OFFICIAL NOTIFICATION OF DECISION

Project# PR-2019-002309
Application#
SD-2021-00173 PRELIMINARY PLAT

For all or a portion of: **LOT 1-A-1 PLAT FOR 1-A-1 AND 5-A-1, LA MIRADA SUBDIVISION** zoned MX-M, located at **4315 WYOMING BLVD NE between MONTGOMERY BLVD NE and LA MIRADA PL NE** containing approximately 15.1868 acre(s). (G-19)

Detail of Utility Easements [36][37] AND [45]

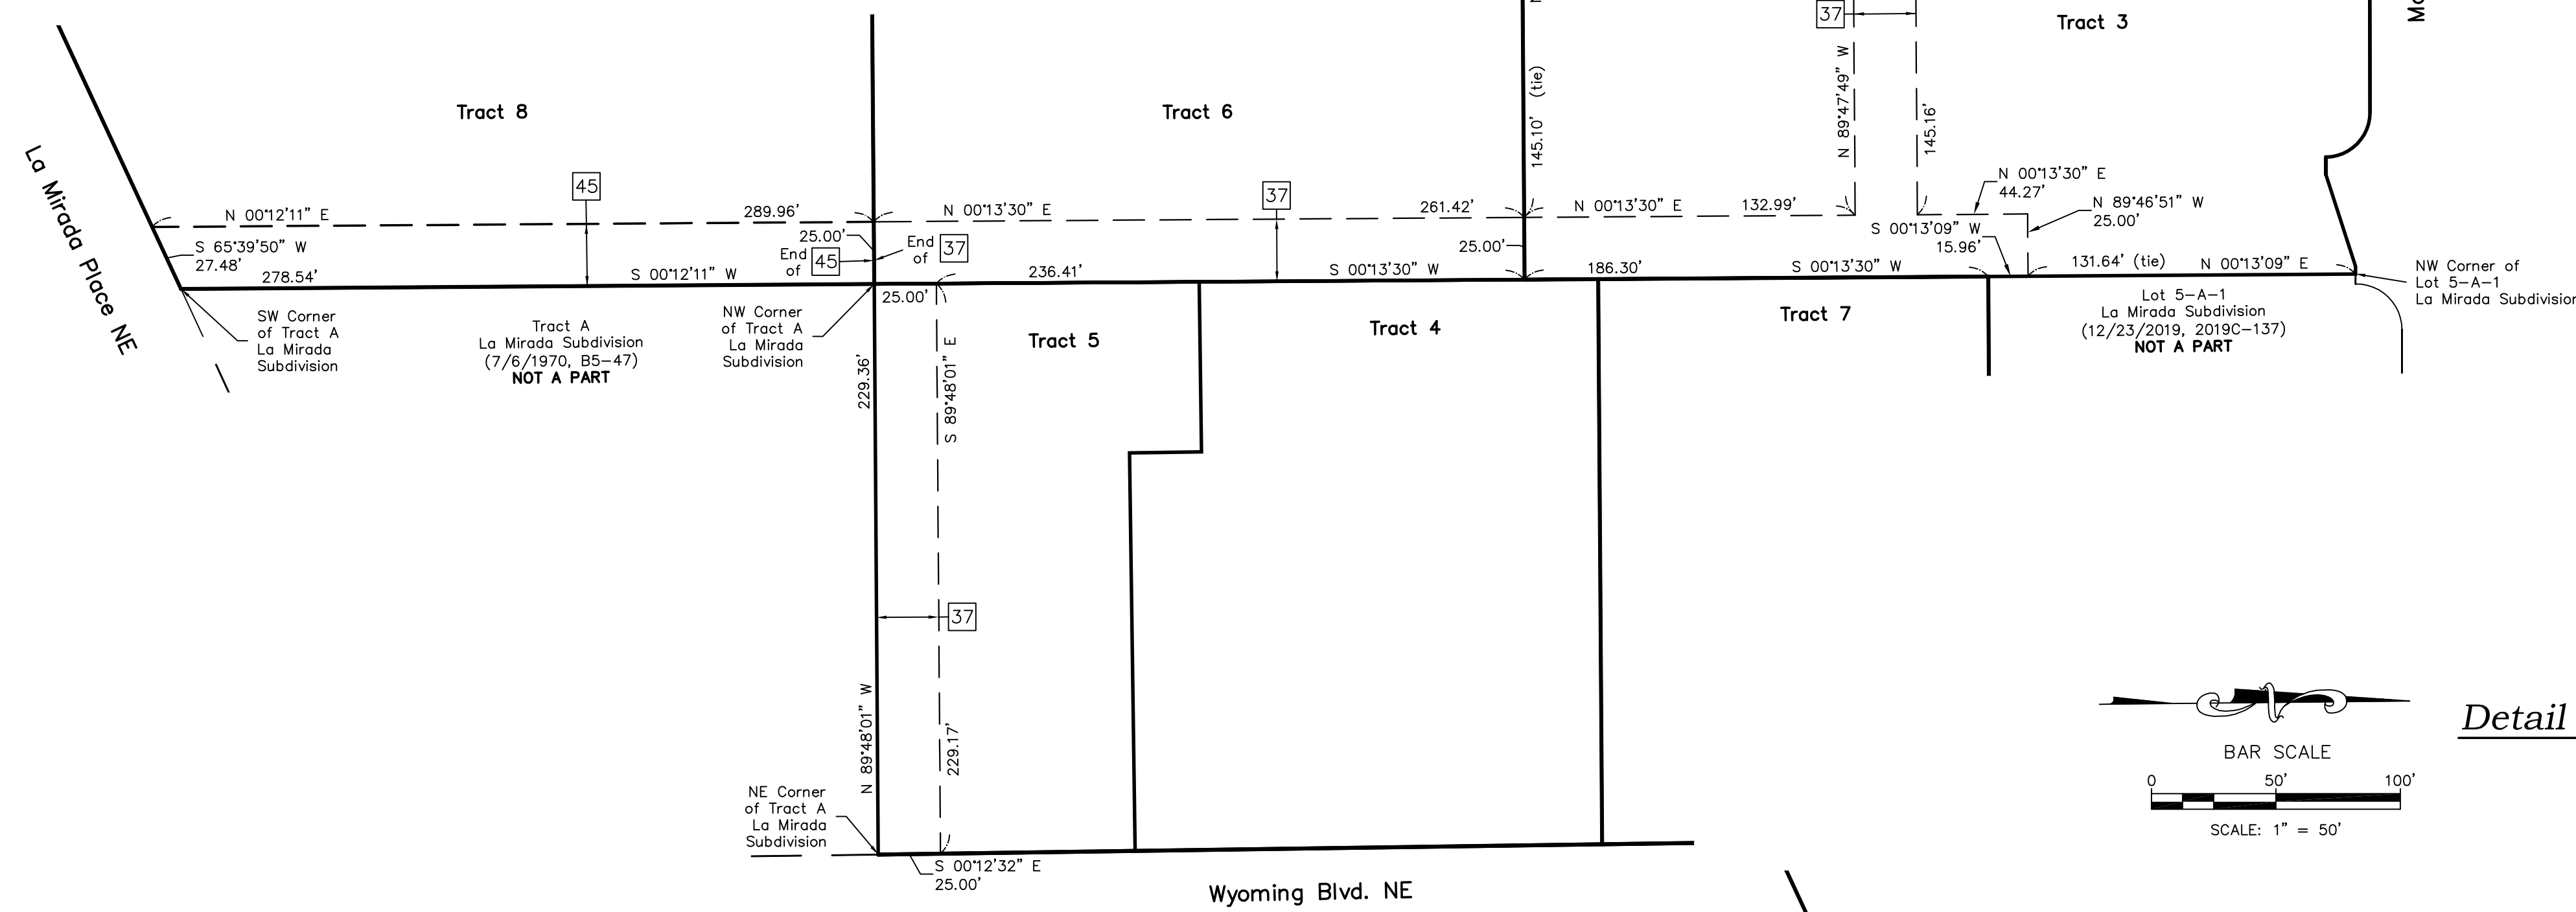
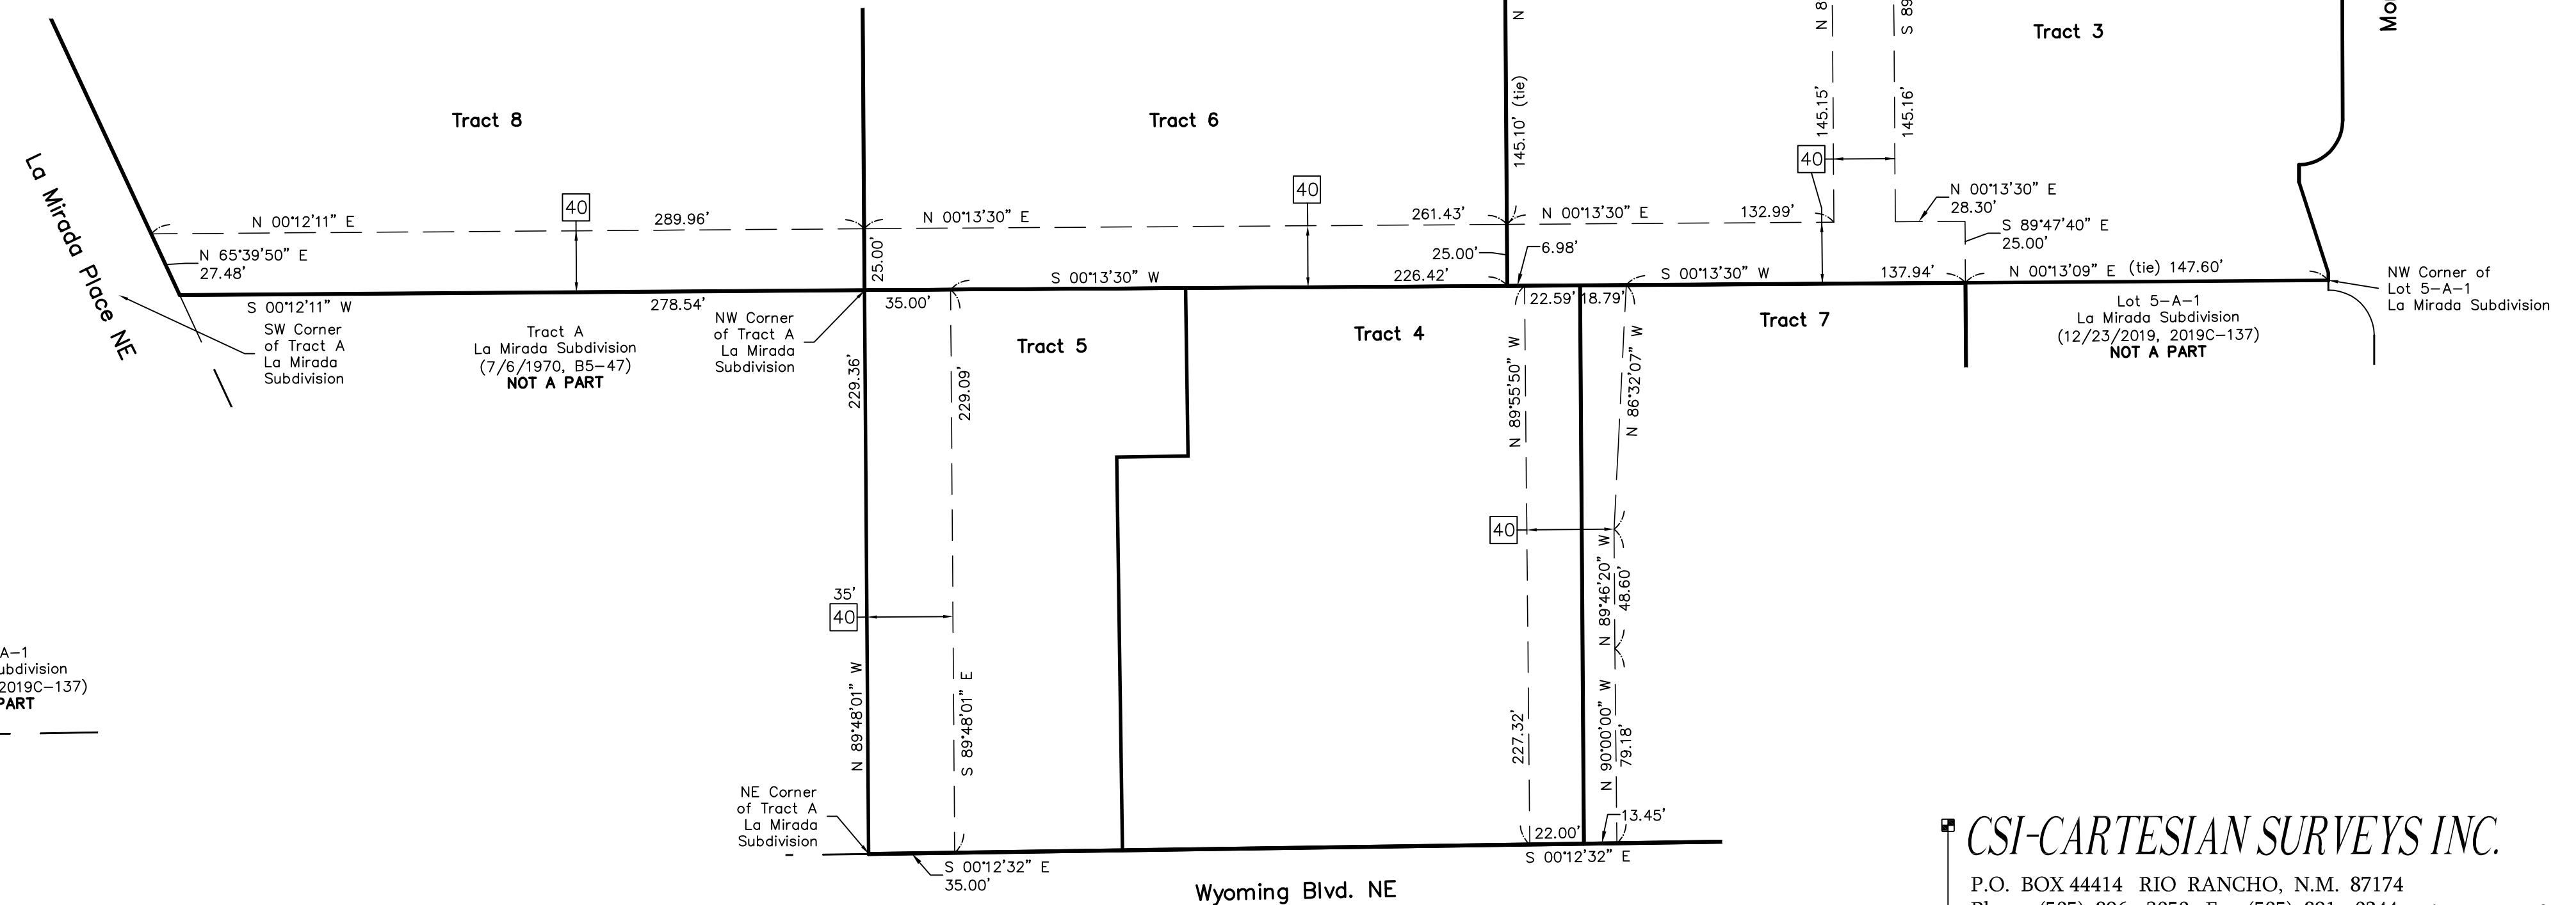
3. Two Infrastructure Lists were approved with this Plat. A recorded Infrastructure Improvements Agreement (IIA) is needed prior to the final DRB sign-off of the Final Plat.
4. Easement notes 36 and 37 shall be updated to reflect 6 total sheets.
5. Prior to Final Plat, the right-of-way shall accommodate the existing bus shelter and the access to Driveway "C" from Wyoming Boulevard, include the ADA pathways.
6. The applicant provided the required notice as outlined in the IDO Table 6-1-1.
